SADDLEHORN RANCH - FILING 5

PRE-DEVELOPMENT GRADING AND EROSION CONTROL PLANS

EPC STORMWATER REVIEW COMMENTS
IN ORANGE BOXES WITH BLACK TEXT

PCD-ENGINEERING REVIEW COMMENTS
IN BLUE BOXES WITH BLUE TEXT

Table VT-1

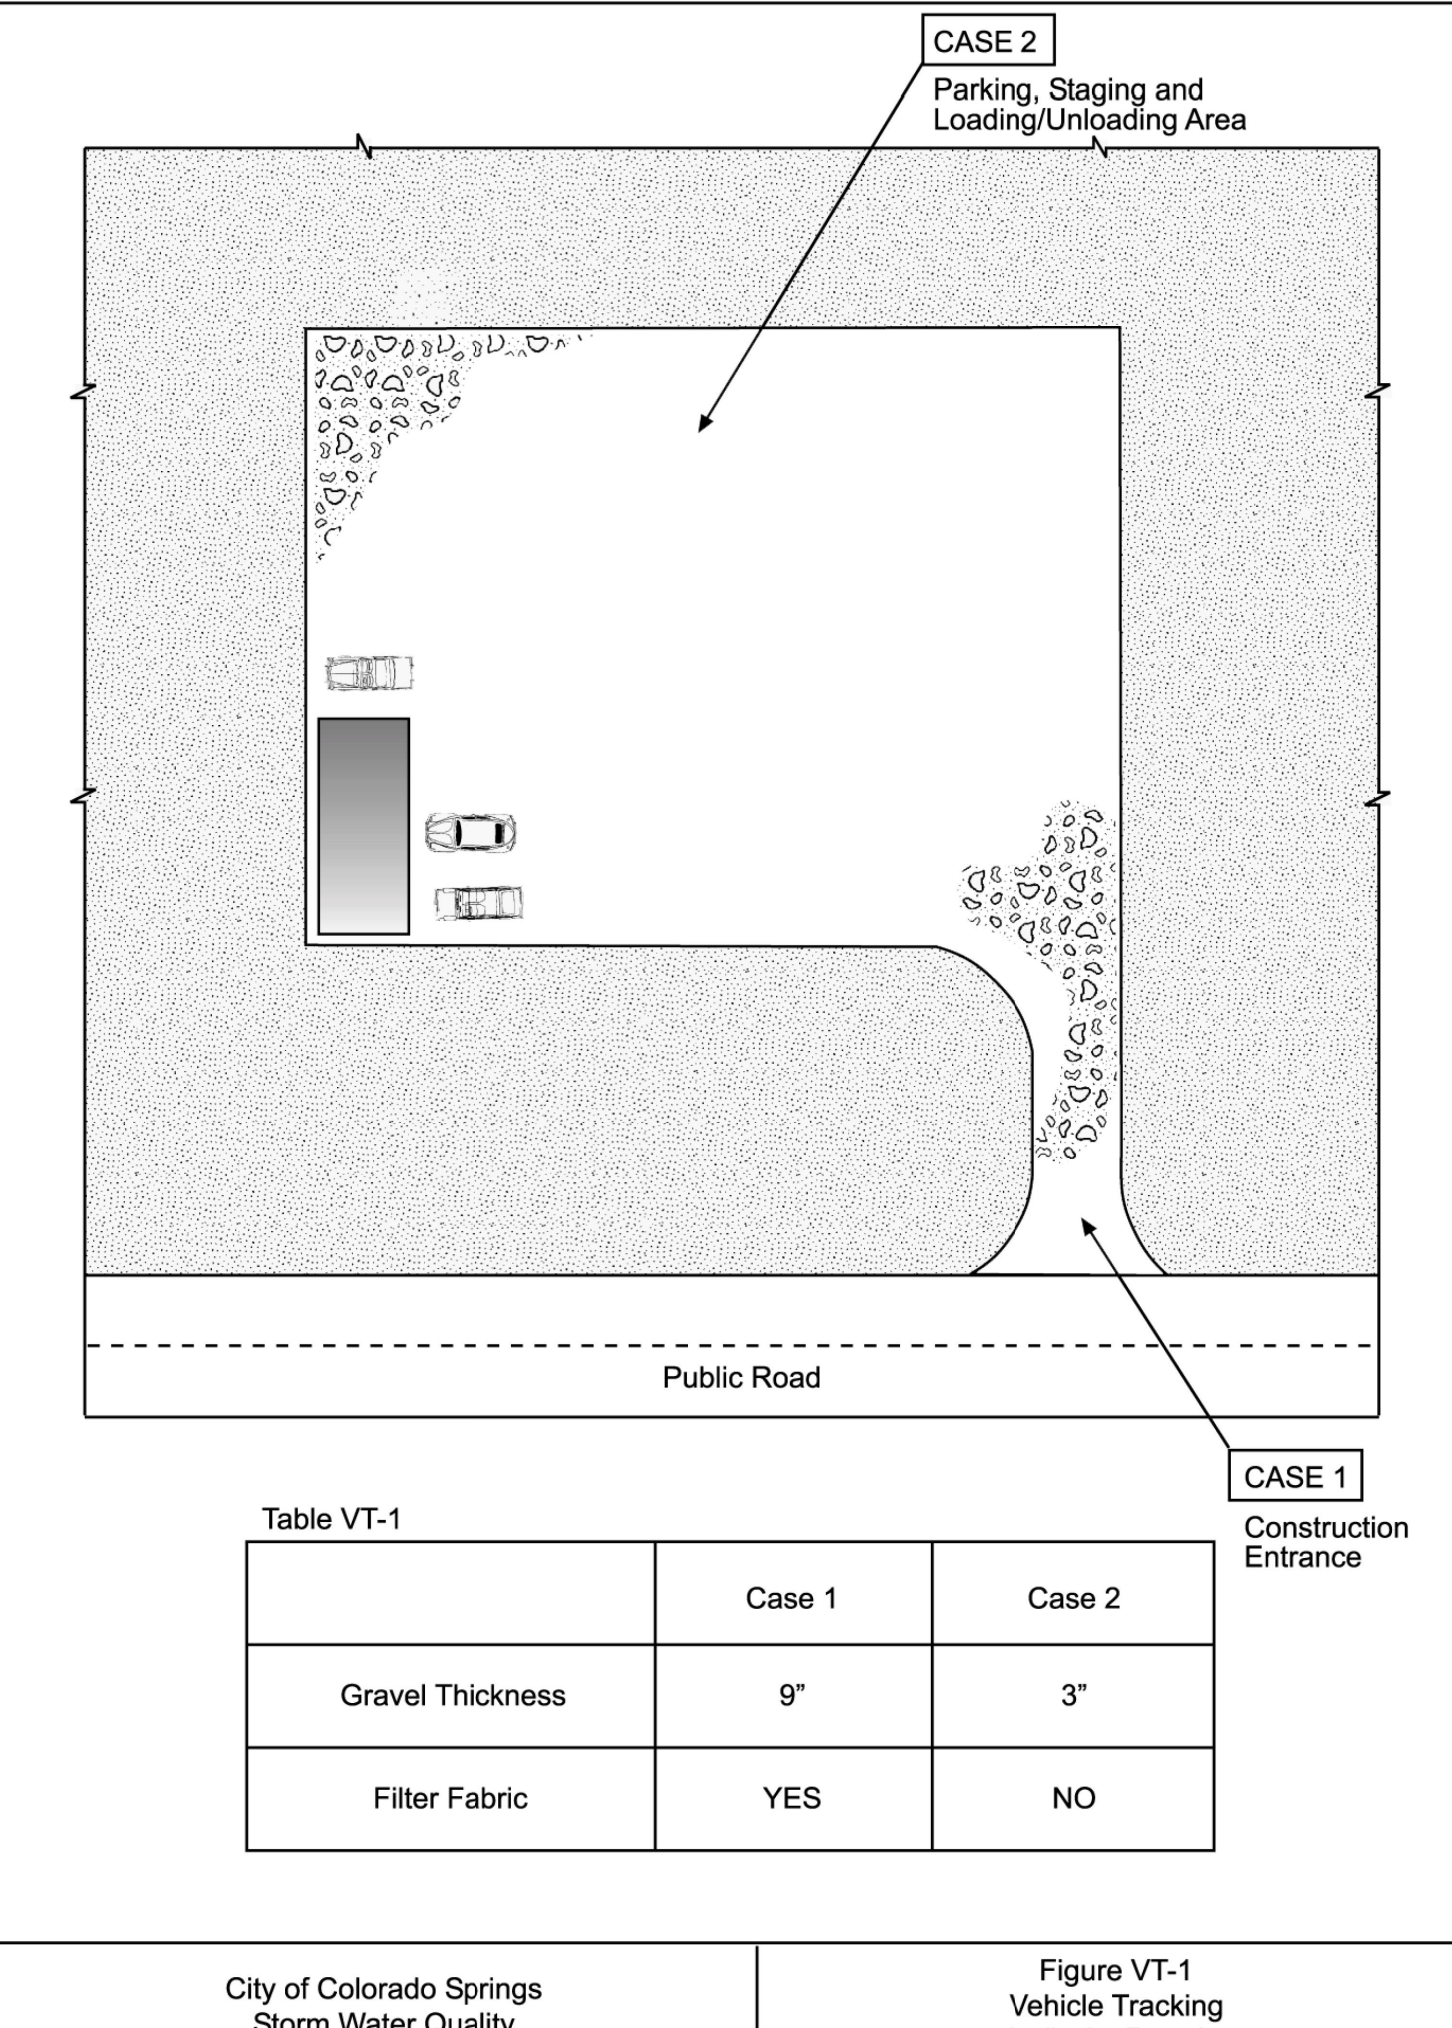
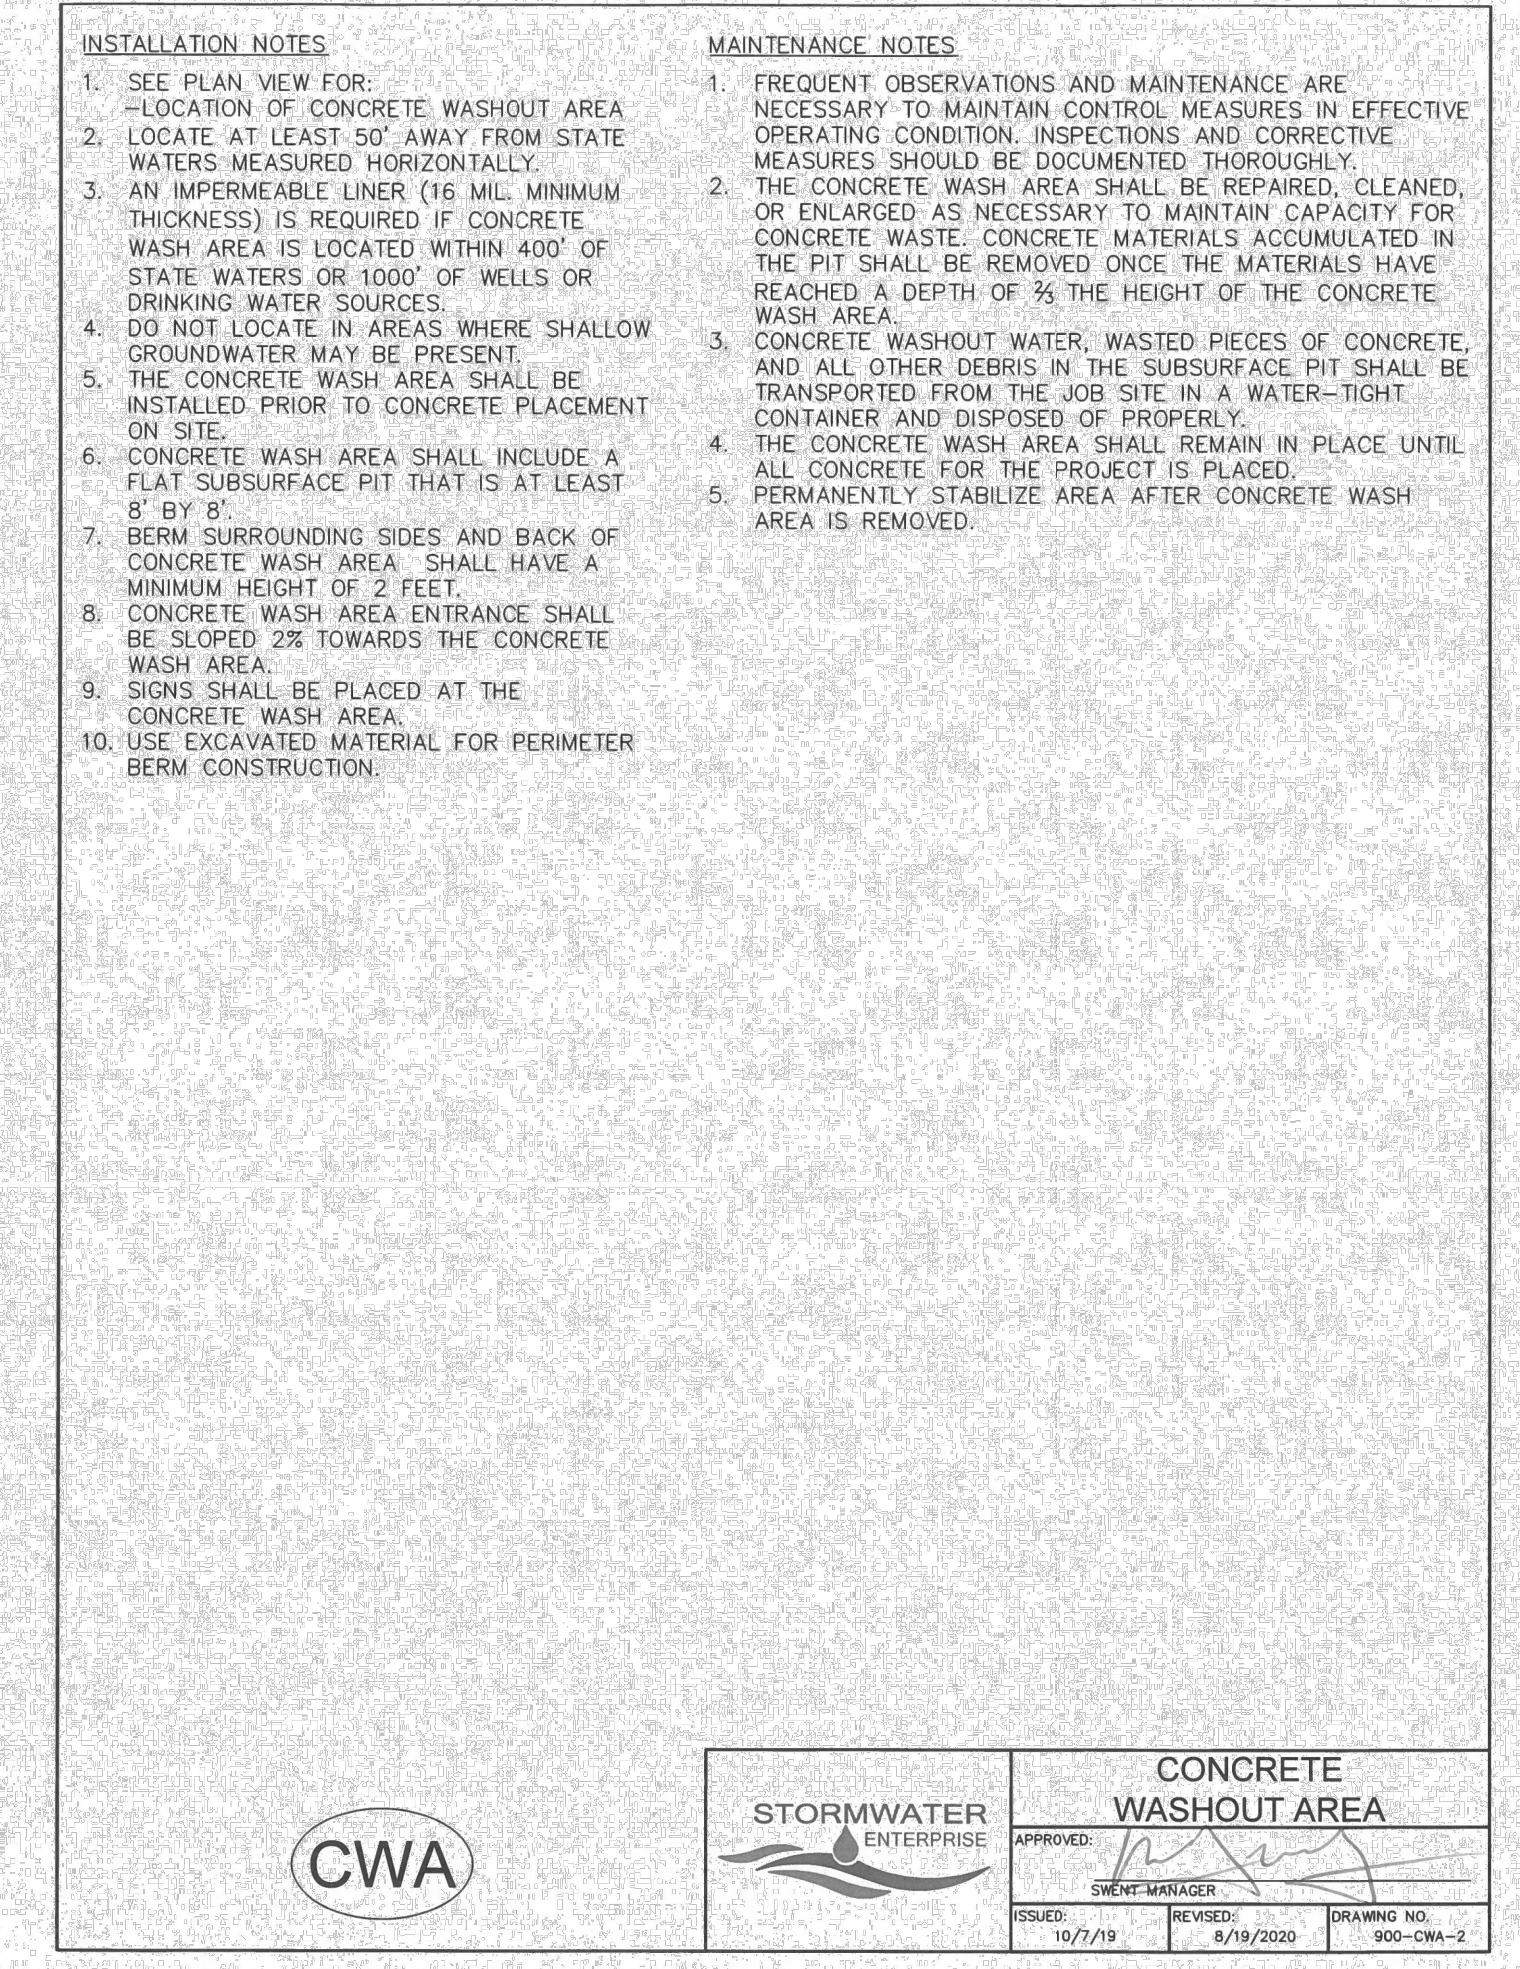
Replace with EPC approved VTC detail (VT-1 and VT-2 in DCMv2, Chap 3.3) or revise to be 75ft min length.
